RE: Spring Tree Ranch Rezone (RZ-24-00002 / CP-24-00002)
Applicant: Pat Deneen
Applicant: Spring Tree Ranch LLC (Owner)

Additional signatures
to this letter originally
submitted 9-11-2024

REVISED SPRINGTREE RANCH MASTER PLAN - SITE PLAN

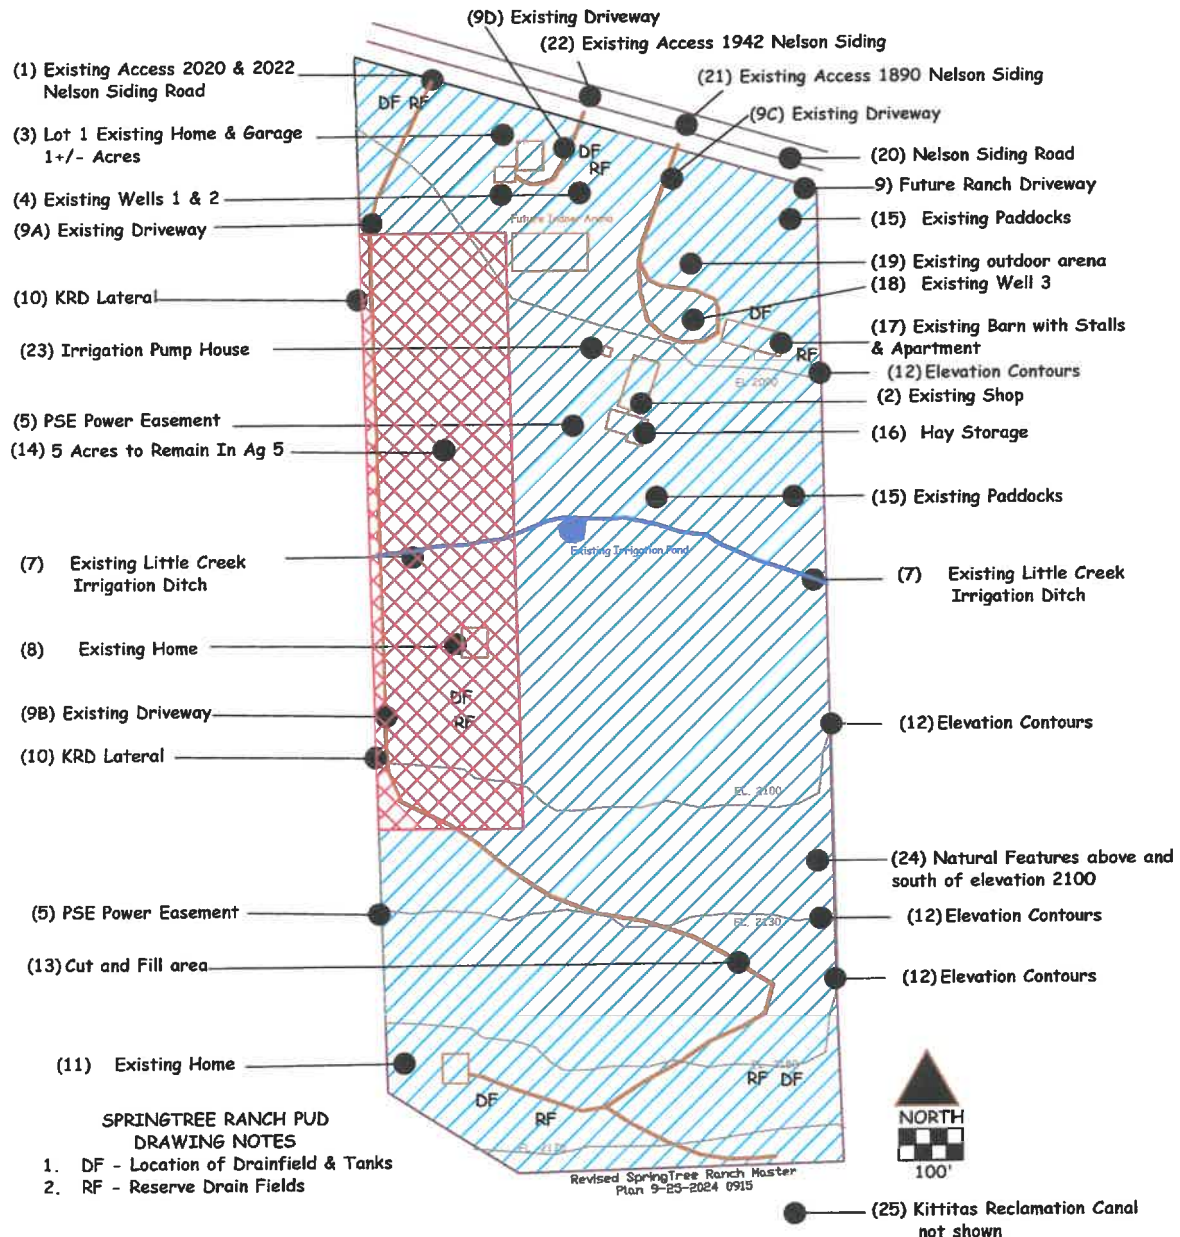
- The proposed indoor arena, according to the map, is directly adjacent to the property lines of parcel 13632 (2144 Nelson Siding Rd) and parcel 13630. What is the proposed set-back from any indoor riding arena from the parcel line? What is the expected noise (DB) increase from this proposed riding arena that will affect these lots and what methods of mitigation are proposed?

- The map and proposal intends to make one large lot of 27.27 acres. Should we be expecting another proposal to subdivide in the future to sell off these homes?

- Much of the proposed land includes open areas that are currently designated on the map as being used as a septic drain field or a reserve drain field. Will septic systems need to be redesigned and/or moved, and have those changes been submitted to the department of health so those proposals can also be reviewed?
